Phone: 0300 123 6780  
Email: [Kathryn.Walsh@lancashire.gov.uk](mailto:Kathryn.Walsh@lancashire.gov.uk)  
Your ref: 3/2024/0885  
Our ref: 3/2024/0885/HDC/KW  
Date: 21 November 2024

**Location:** Spring Barn Old Nab Road Langho BB6 8DY  
**Proposal:** Proposed demolition of pagoda and construction of single storey, rear extension. Addition of solar panels to west roof slope of existing dwelling.  
**Grid Ref:** 371475 433734

pl.20

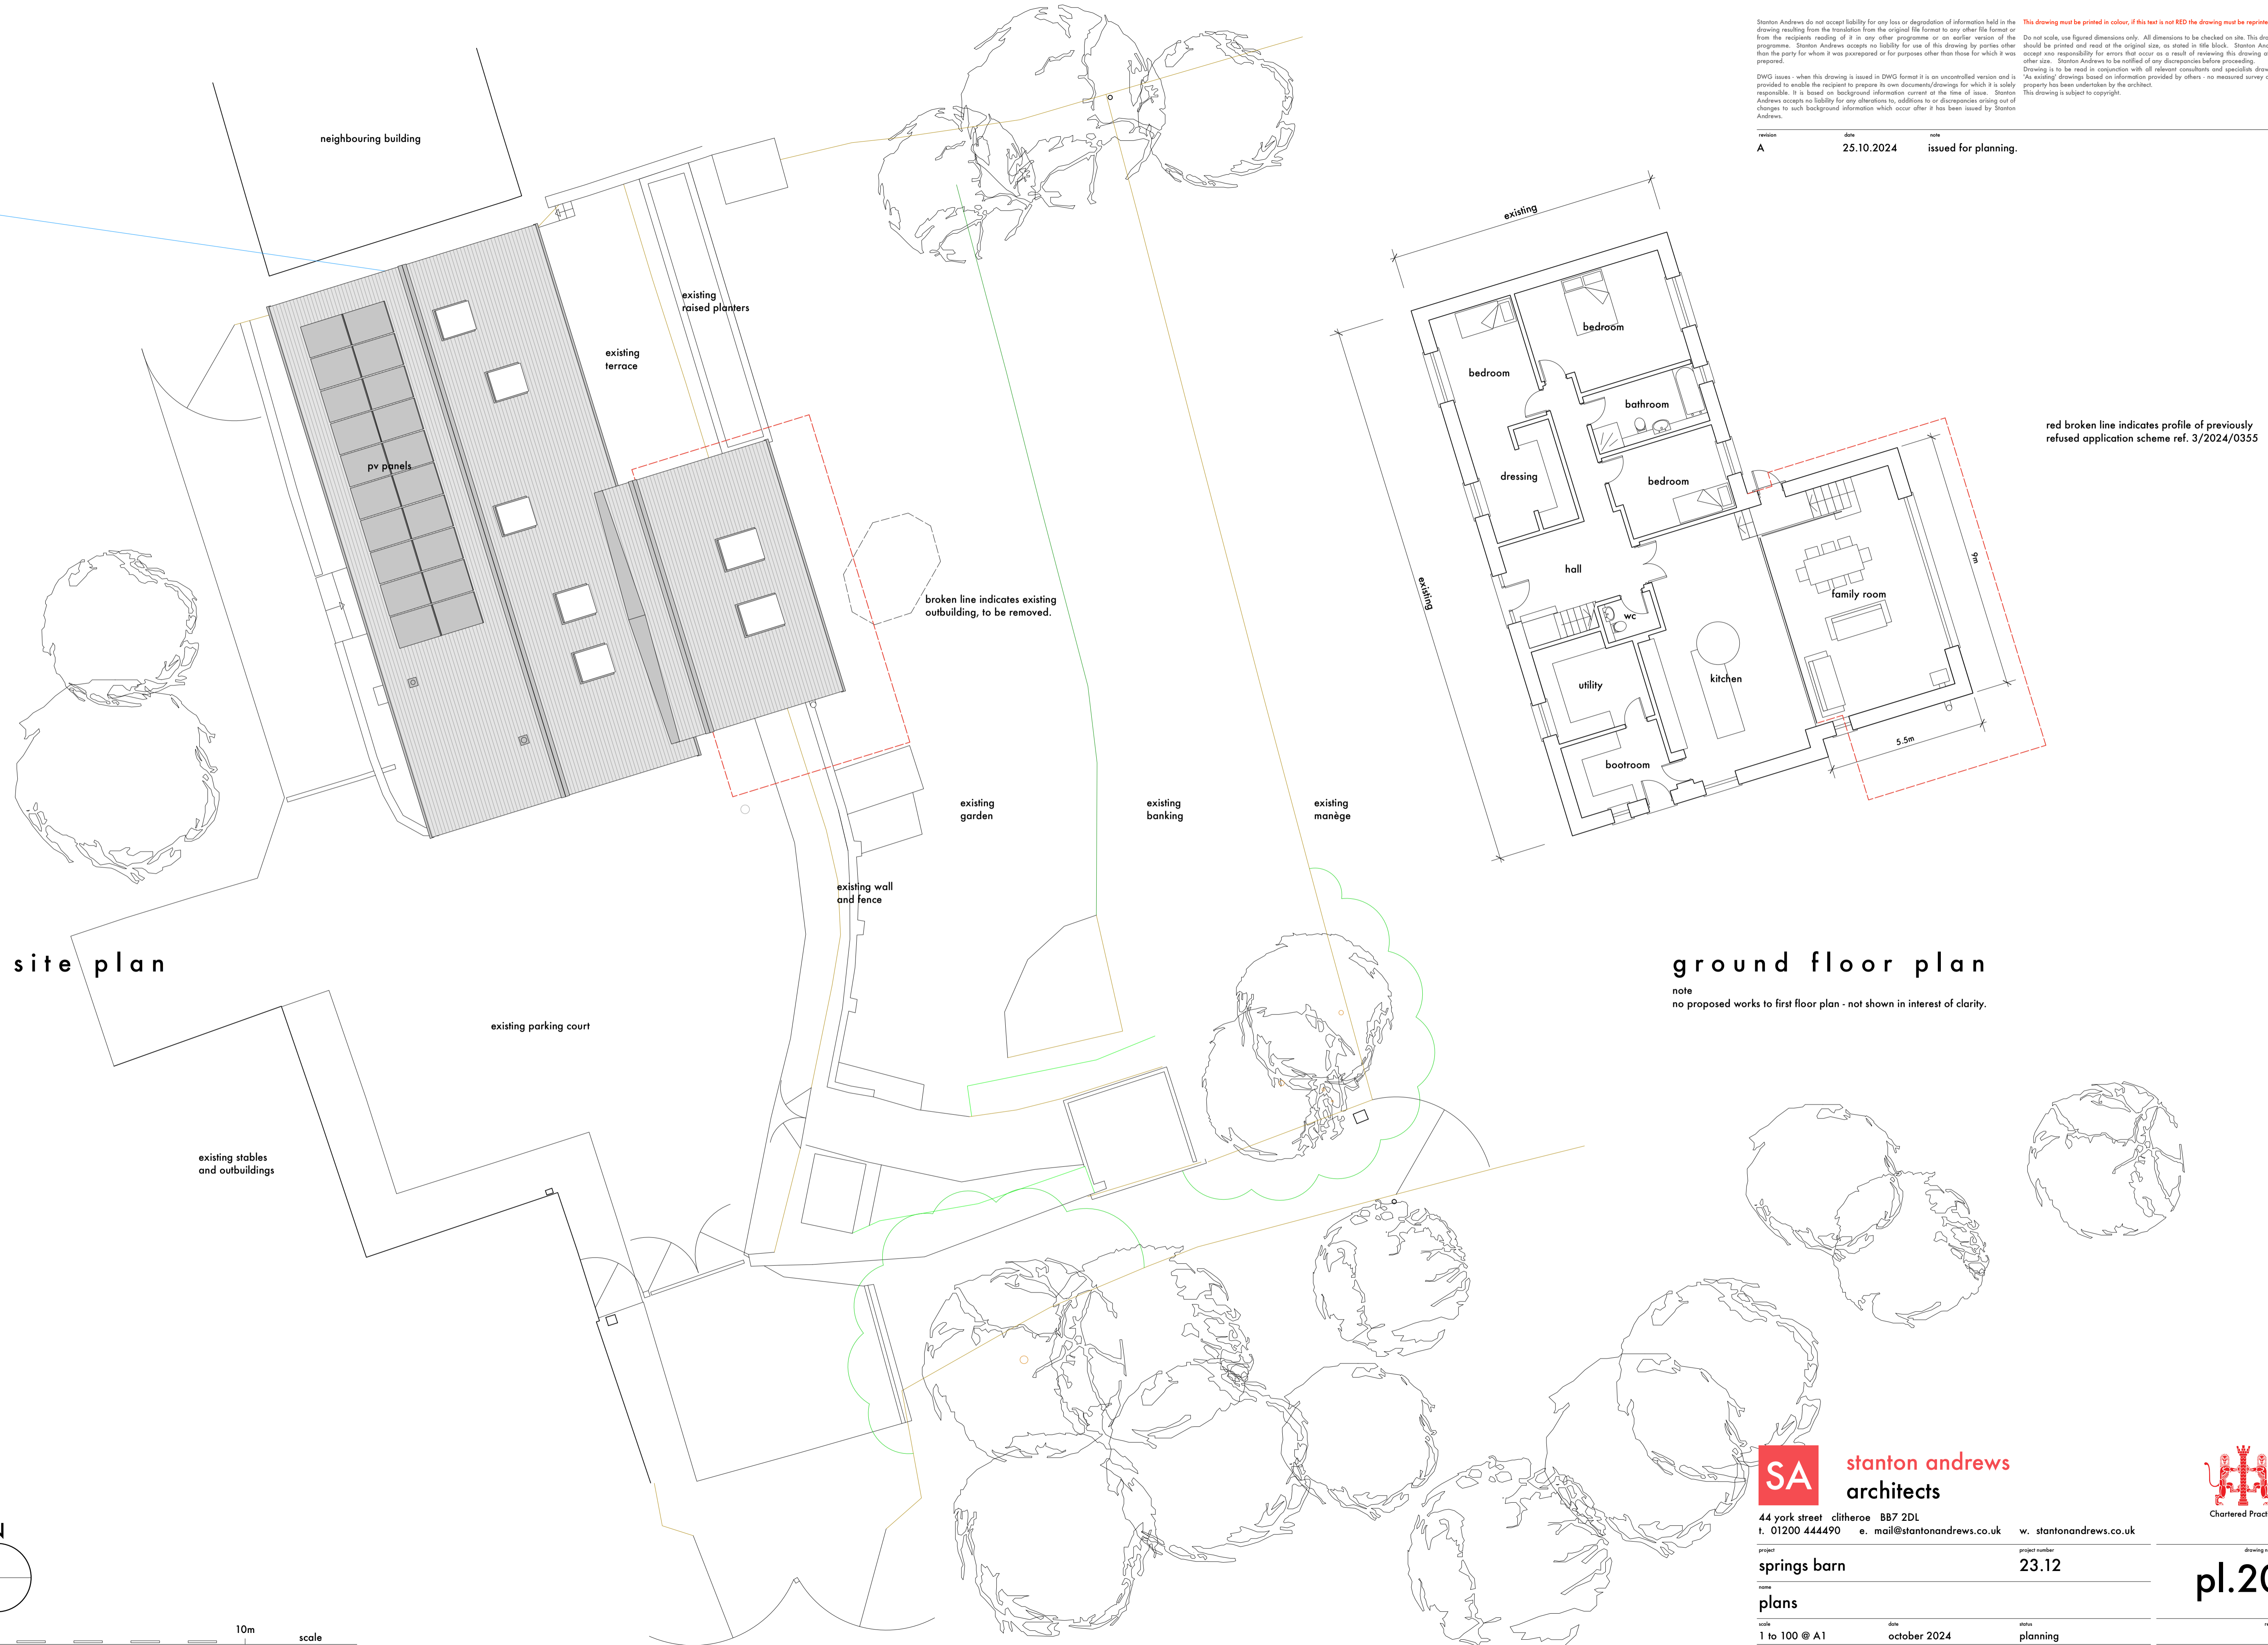
The LHA has reviewed drawing number pl.20 and are aware that the dwelling complies with the LHAs parking standards as defined in the Joint Lancashire Structure Plan. There is also room to turn within the site and leave in a forward gear. As such, the effect of the development on the operation of the local highway network would be negligible.
